14 May 2026

ATT: Michelle Niles  
Department of Planning and Environment

In reference to State Significant Development application for Detailed Design for shop-top housing with in-fill affordable housing - 45-53 Macleay Street Potts Point (SSD-83867719).

Ausgrid would like to thank you for seeking input and feedback regarding the Environmental Impact Statement (EIS). Ausgrid has undertaken a review of the EIS and associated information in relation to potential impacts or interfaces with Ausgrid's electricity infrastructure.

Figure 2: Network Plan Within the Vicinity of The New Development Site (Source: DBYD)

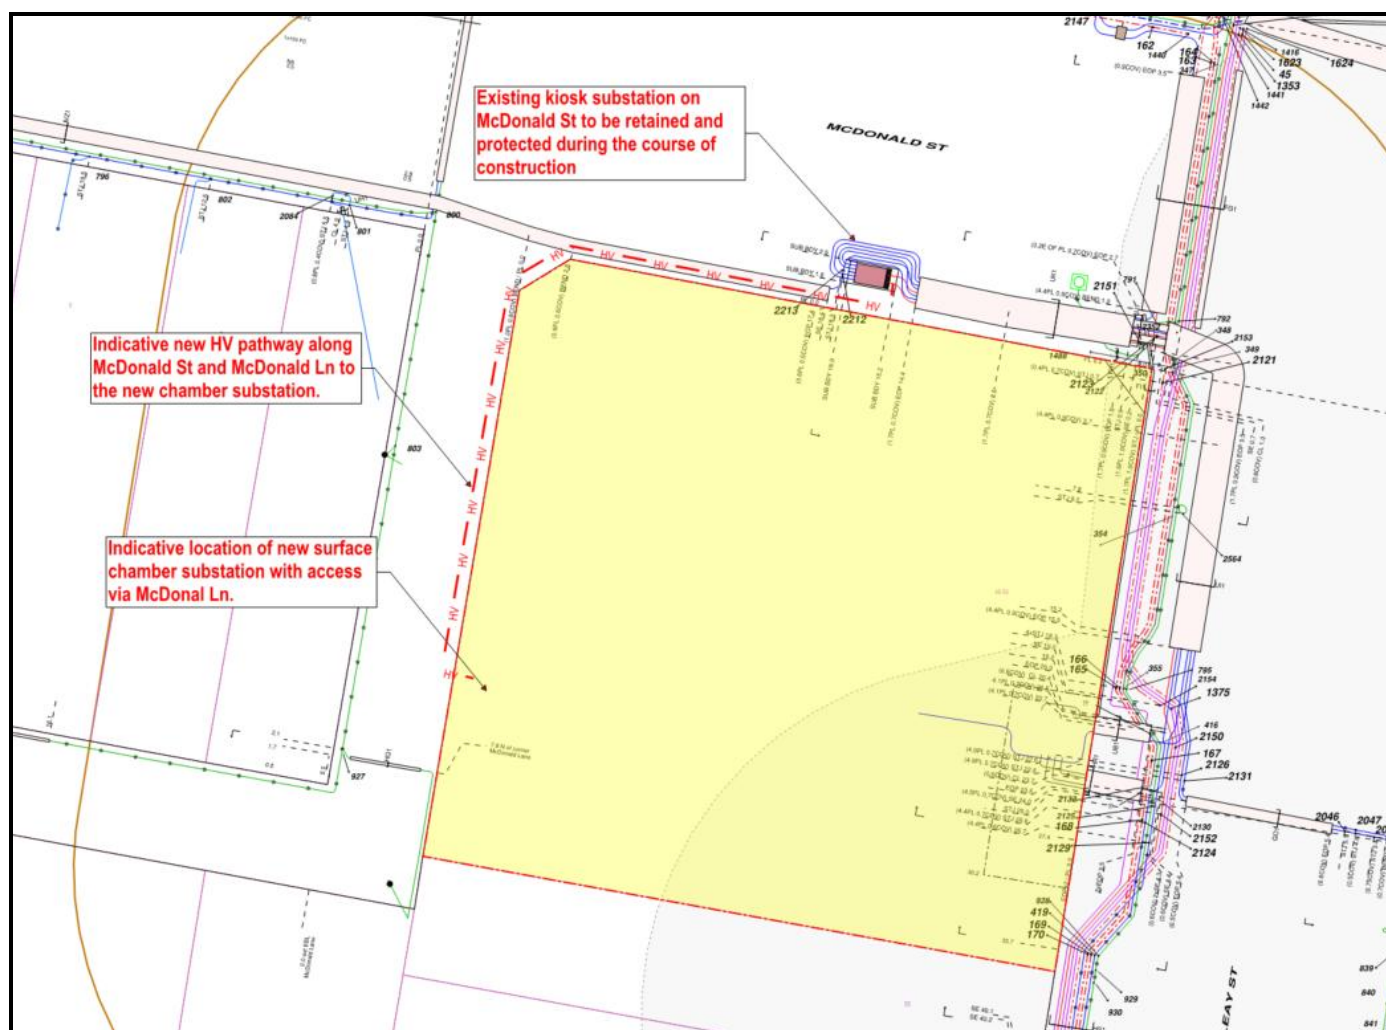
There is an existing kiosk style electricity substation on McDonald St that may be impacted by the proposed construction. Subsidence and vibration must be minimised at the substation site. The use of ground anchors under a substation is generally not permitted due to the presence of underground cabling and earthing conductors which may be more than 10m deep. A further area of exclusion may be required in some circumstances.

In addition to above, Ausgrid requires substation ventilation openings, including duct openings and louvered panels, to be separated from building ventilation system air intake and exhaust openings, including those on buildings on adjacent allotments, by not less than 6 metres.

Any portion of a building other than a BCA class 10a structure constructed from non-combustible materials, which is not sheltered by a non-ignitable blast-resisting barrier and is within 3 metres in any direction from the housing of a kiosk substation, is required to have a Fire Resistance Level (FRL) of not less than 120/120/120. Openable or fixed windows or glass blockwork or similar, irrespective of their fire rating, are not permitted within 3 metres in any direction from the housing of a kiosk substation, unless they are sheltered by a non-ignitable blast resisting barrier.
